From: Tim Lawson [REDACTED]
Sent: 10 November 2022 16:58
To: info@sunnica.co.uk; Sunnica Energy Farm <Sunnica@planninginspectorate.gov.uk>
Cc: Scott Harker [REDACTED]
Subject: Final Points on the Sunnica Application before 11.11.22

Subject: Sunnica East - Junction I off Newmarket Road towards Barton Mills

Subject: Deadline 4 Submissions -- EN010106: Sunnica Energy Farm

SUNNICA EAST SITE B,
SITE ACCESS I (SE-I)
NEWMARKET ROAD

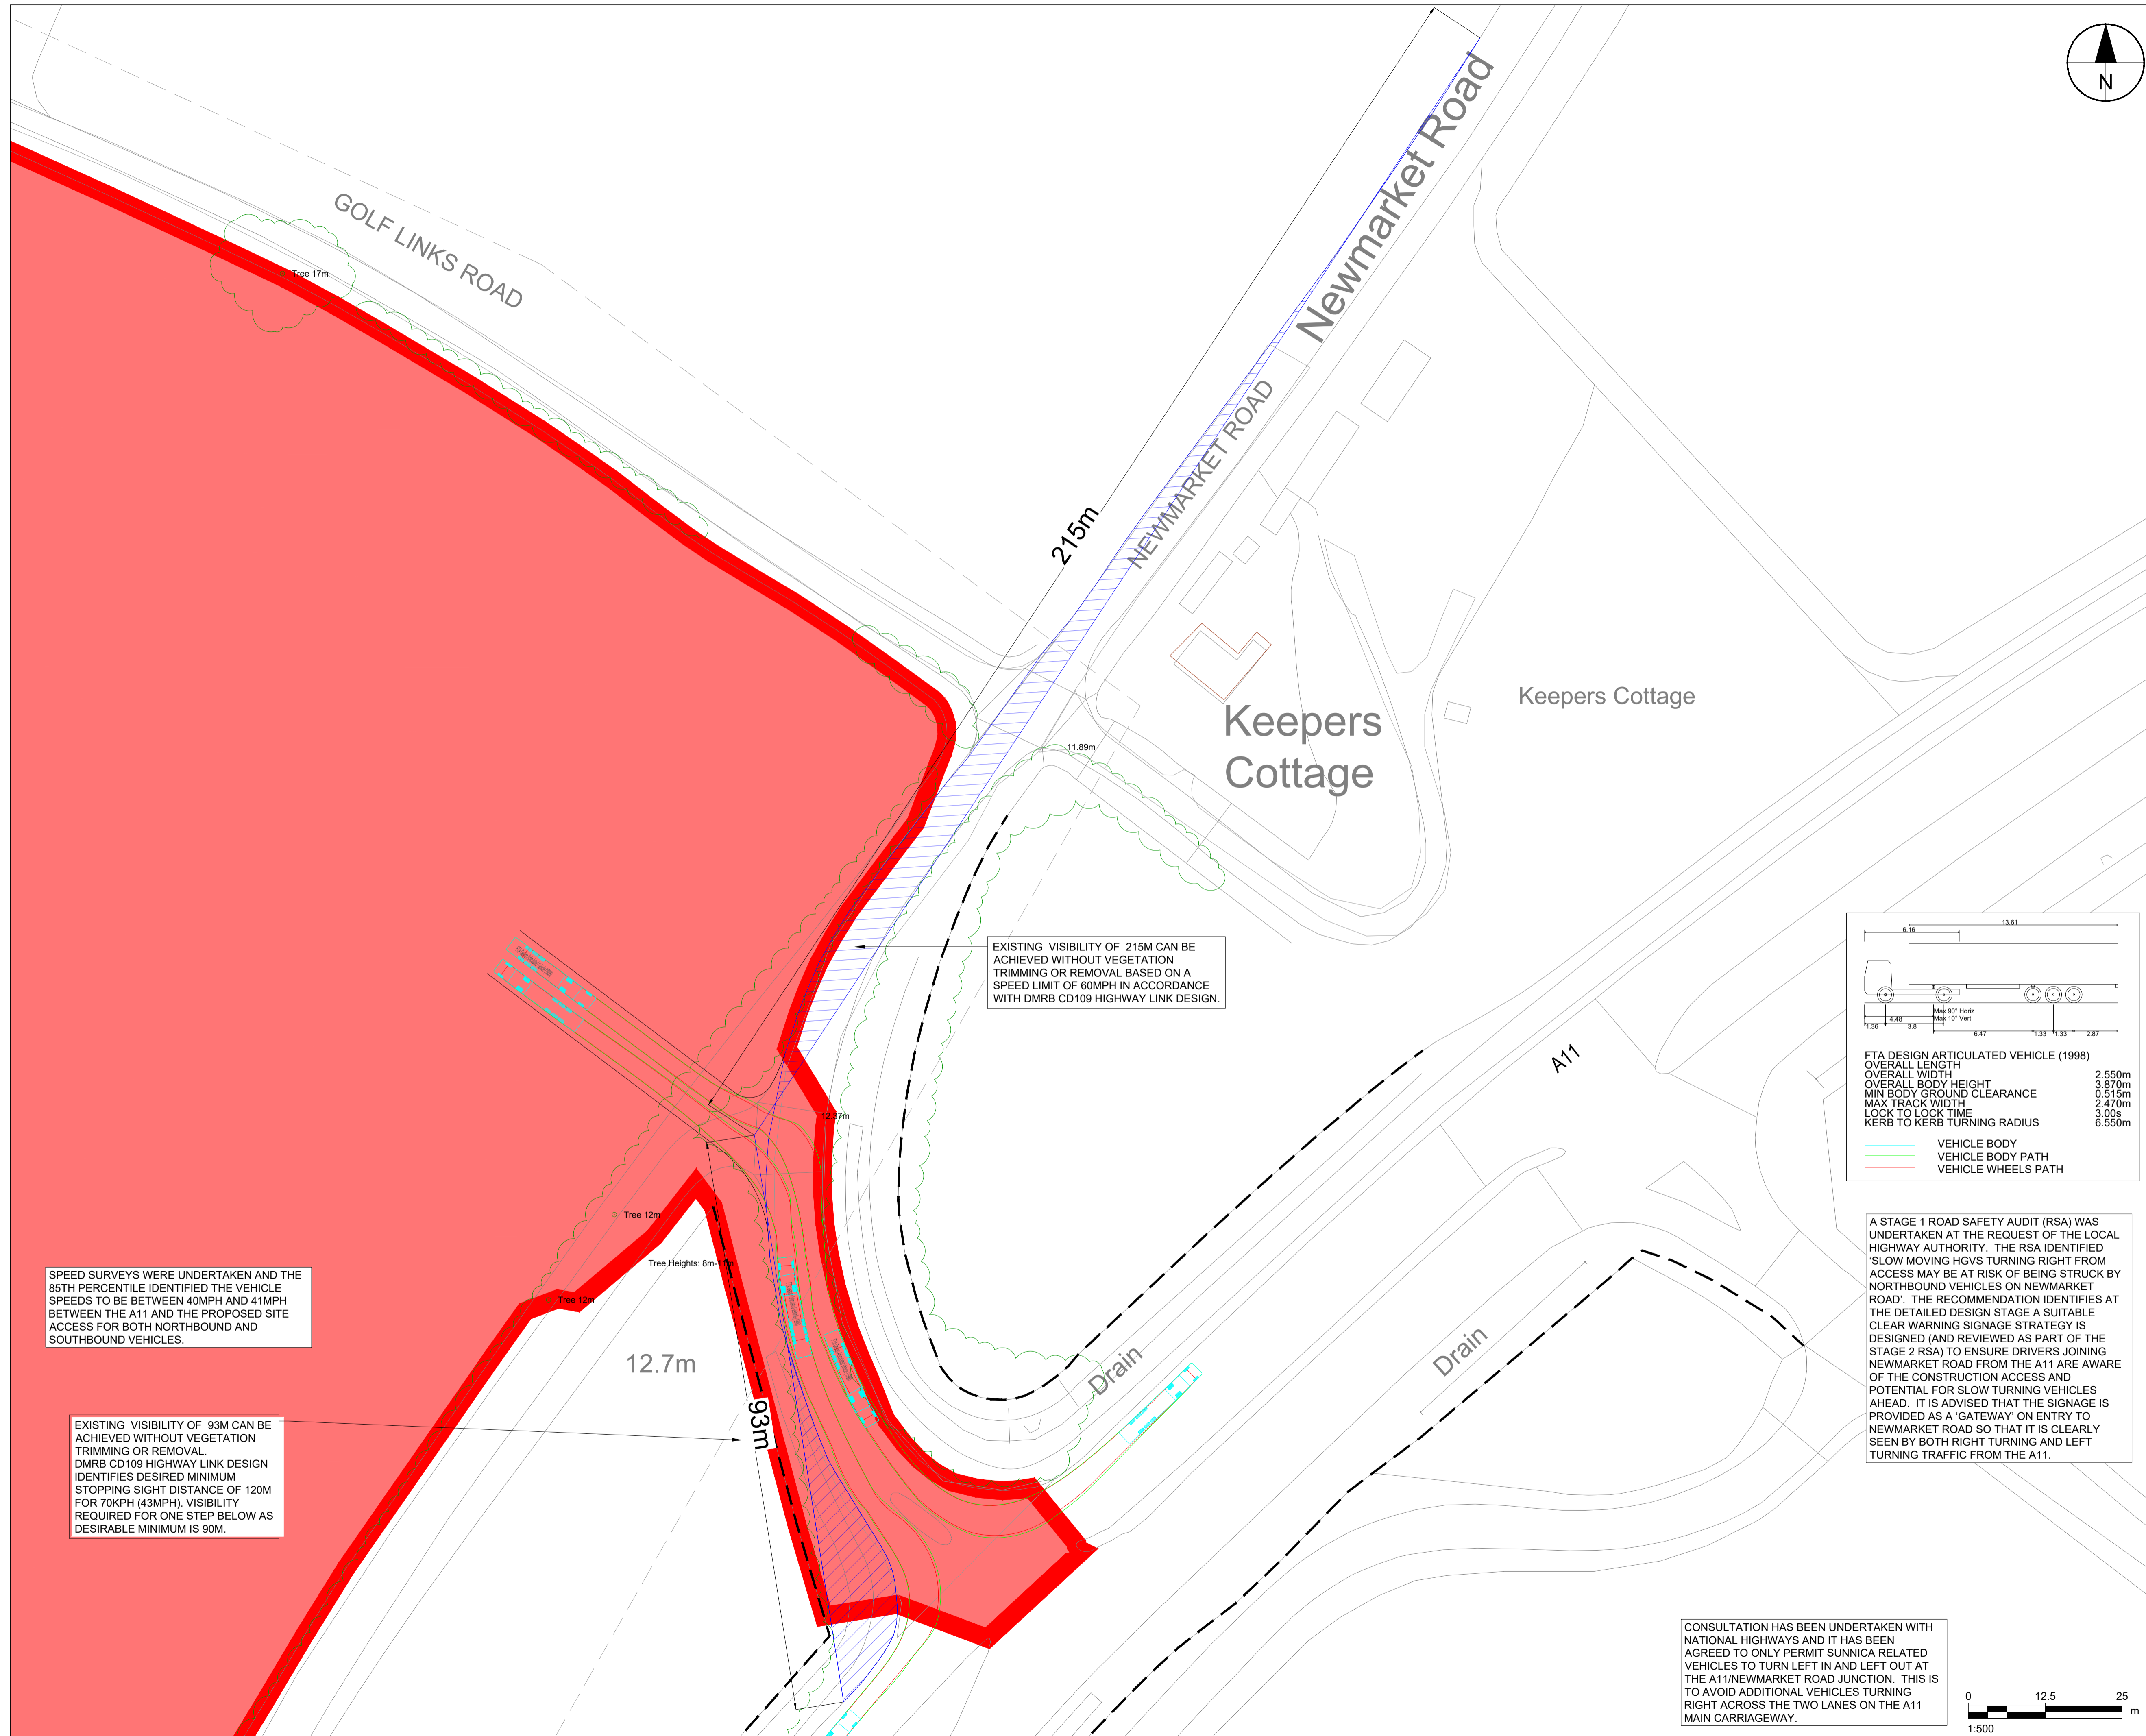
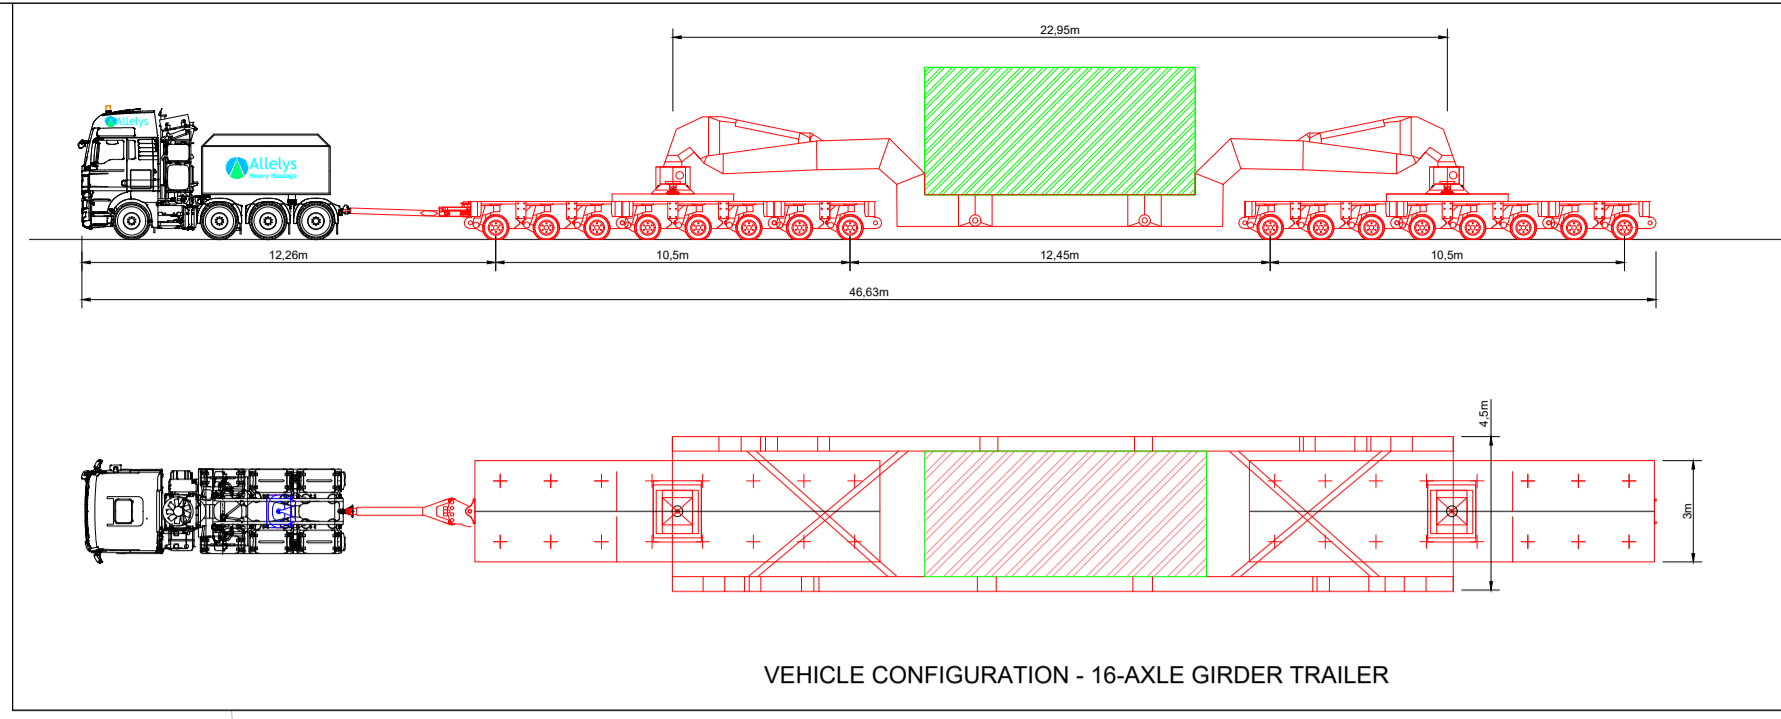
I have today received all the Deadline 3.A papers and am most surprised to find that in the Environmental Statement 6.2 Appendix 13 C – Traffic Management Plan Appendix C 3 of 7 (clean) Rev 3 – to which is attached an enlargement plan – Sheet ACM 60589004 – AMR – DR – 0014 – that shows very clearly that:-

- Where the words “FTA Design Articulated Vehicle 1998” appear within the green boundaries – also stating HGV Left IN and Right OUT (missing the “h”) -- It is clear that the present use of the way IN off the A.11 is going to be seriously compromised by these two new lanes partially on/in the existing Newmarket Road boundary.

I had assumed that the HGV ways in and out would be TOTALLY separated from and to the south of the normal use of Newmarket Road towards Barton Mills and thus GLR also.

- I suggested that some of the totally “waste” triangular area to the south & parallel to the A.11 should be used to:-
 - (i) Provide a deacceleration lane off the A.11 for HGV’s entering the North East site (if permitted);
 - (ii) Improve the visibility splays especially for HGV’s leaving the site heading to the North.

Please explain to me HOW (as proposed in that drawing) when I am turning left off the A.11 at the new/amended junction I can avoid having to use the new HGV “in” route in order to get onto Newmarket Road and thus have to cross/compete with outgoing HGV’s in order to get onto it so as

to thereafter turn left into GLR? Or are you intending to close normal traffic on Newmarket Road and thus GLR all together during the construction phase?

The statement about “average traffic speeds on the A.11 on both North & South carriageways being 48 mph” is farcical and must have been done on a Friday or Sunday with very heavy (thus slow) Coastal related traffic on the A.11 – I used that road two times every week (in both directions and in mornings and evenings) for about 18 years and on many occasions I was overtaken by cars doing well over the statutory speed limit!! If planning this access is being based on that assumption + a few “slow-down” signs – there will be many deaths at this point!

Please may I have an early answer to my “HOW” point above AND an assurance that your company and your traffic advisers will look again at changing this “N E Site - Access I” to becoming one that is WHOLLY separated from the present Newmarket Road junction off the A.11?
